ABP / MCC / Irish Water Consultation Summary

Dunshaughlin East SHD

Doc No. WS-01 Rev A (07/12/18)

CLIENT		TITLE	
Rocktecture 1 Limited		Attenuation Details - Storm Catchment No. 2	
PROJECT		SCALE	
Proposed Strategic Housing Development at Dunshaughlin East		1:250 @ A1	
JOB No.		DATE	
J18-001		Nov 2018	
DRAWING No.		DRAWN BY:	
022		MS	
REV		CHECKED BY:	
A		MS

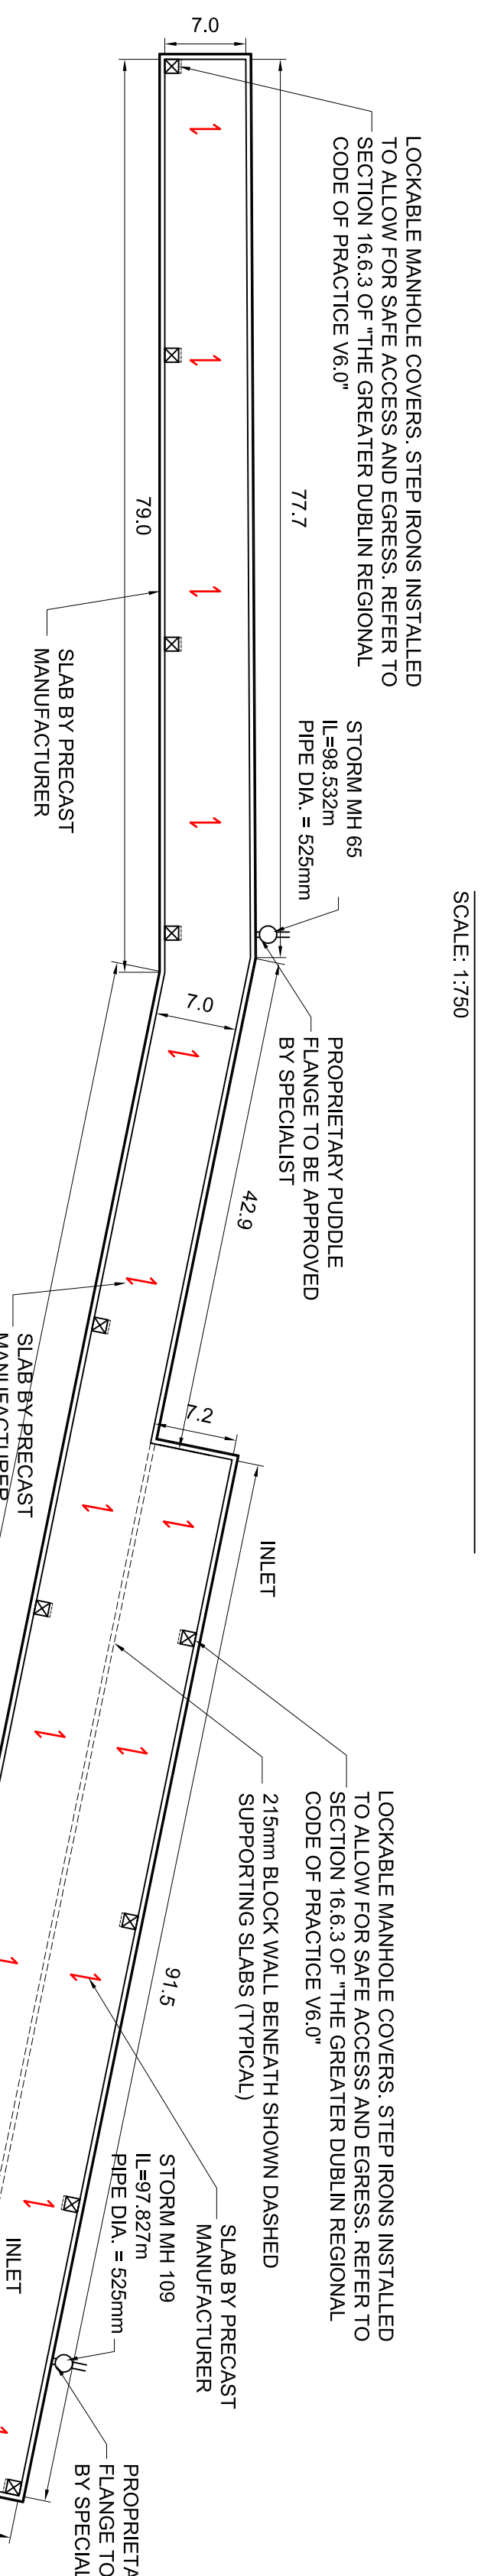
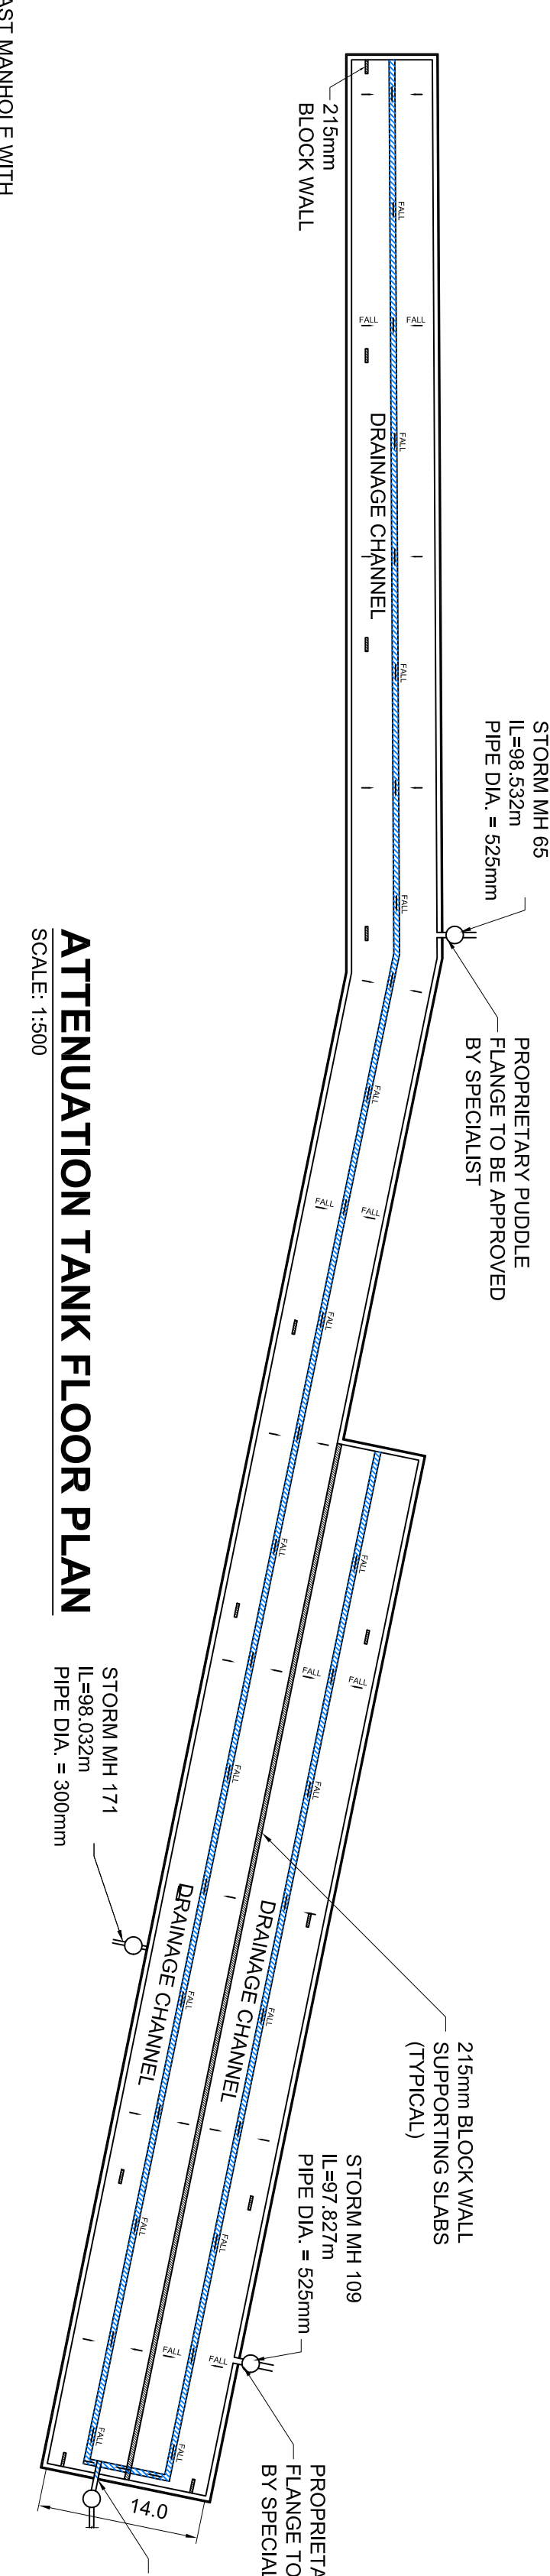
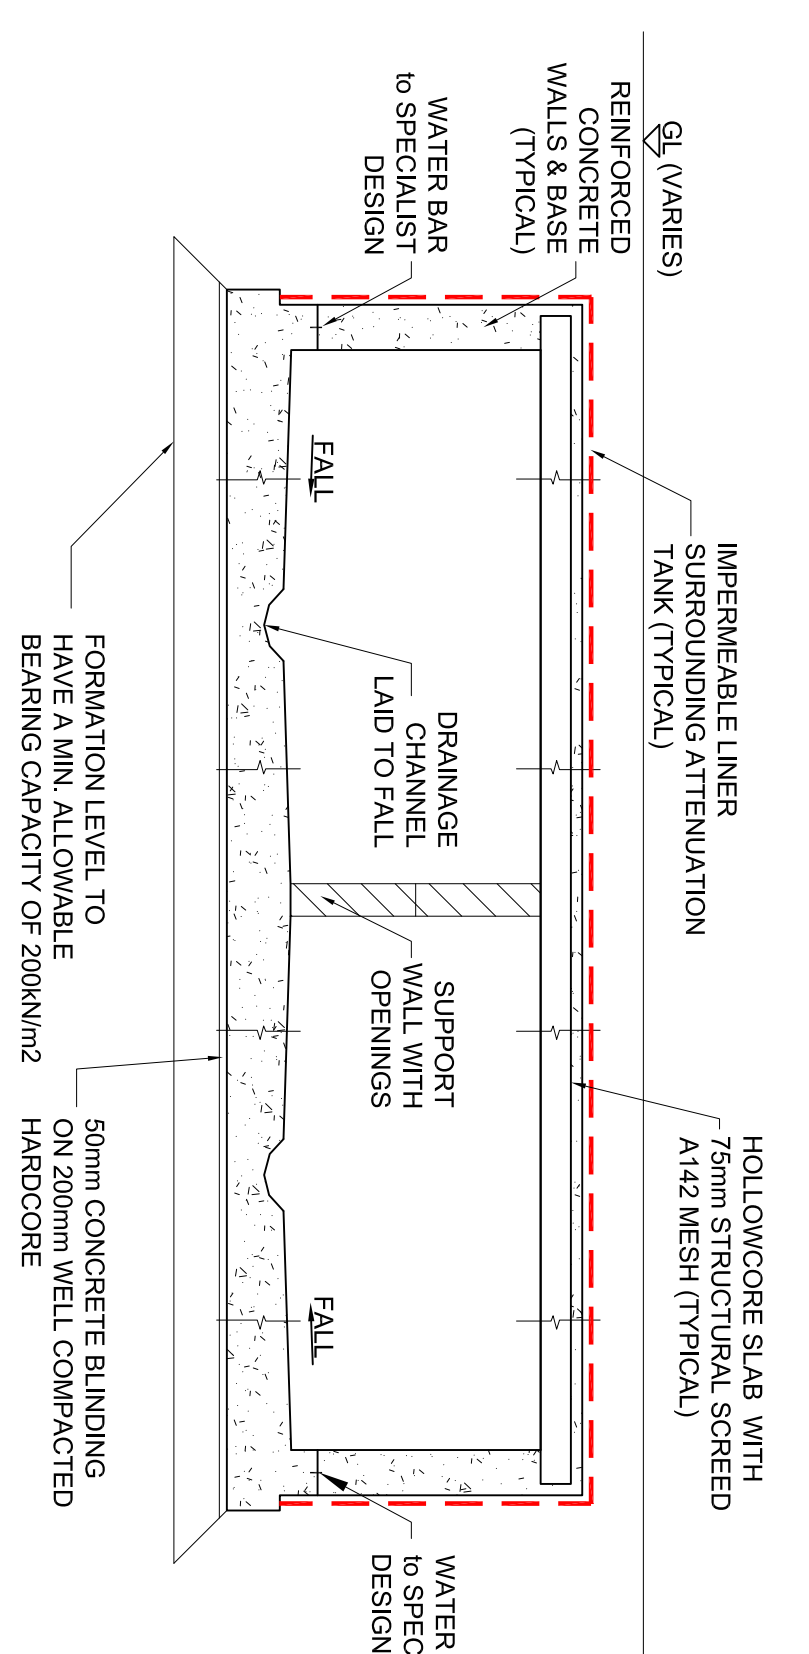
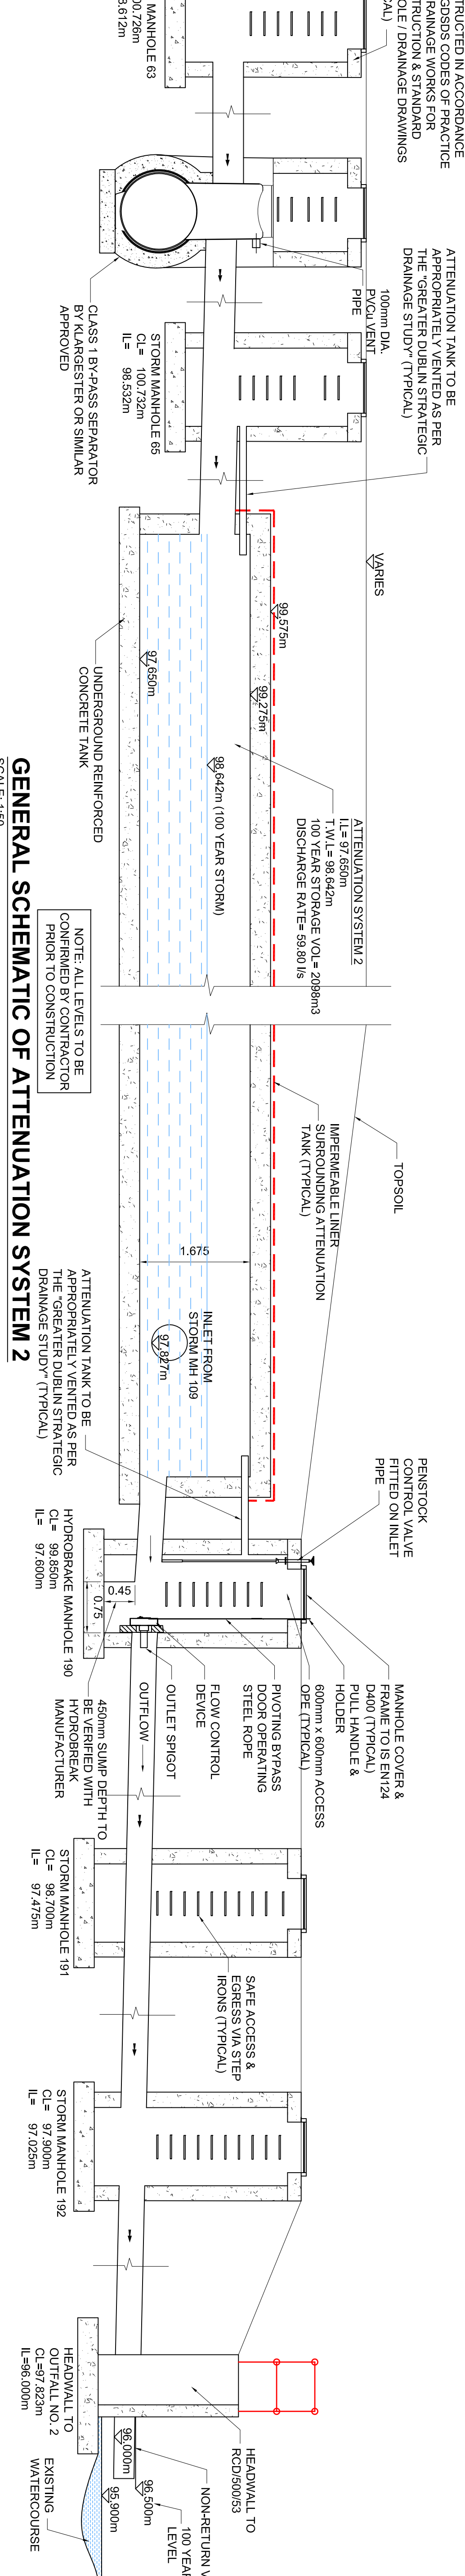
4. Prior to commencing construction the applicant shall submit results of the ground water level monitoring at each of the proposed attenuation sites. The water table level shall be clearly indicated relative to the proposed attenuation system invert level and appropriate measures implemented to ensure the attenuation system does not become inundated with ground water. The proposed attenuation system shall be acceptable to the MCC Water Services Engineer.

1. All surface water drainage design shall comply fully with the Greater Dublin Strategic Drainage Study (GSDSDS) Regional Drainage Policies Volume 2, for New Developments.
2. Permeable paving omitted from public car park spaces and shown in privately owned car parking spaces only.
3. The applicant shall install a non-return valve on the proposed discharge Outfall No.2. Prior to construction the applicant shall submit details for the non-return valve which shall be acceptable to MCC Water Services Engineer
4. Following consultation with MCC and reviewing initial results from the ground water level monitoring process it was concluded that a fully sealed attenuation system was required due to high ground water levels. With regards this the preferred attenuation system of MCC was underground concrete tanks.
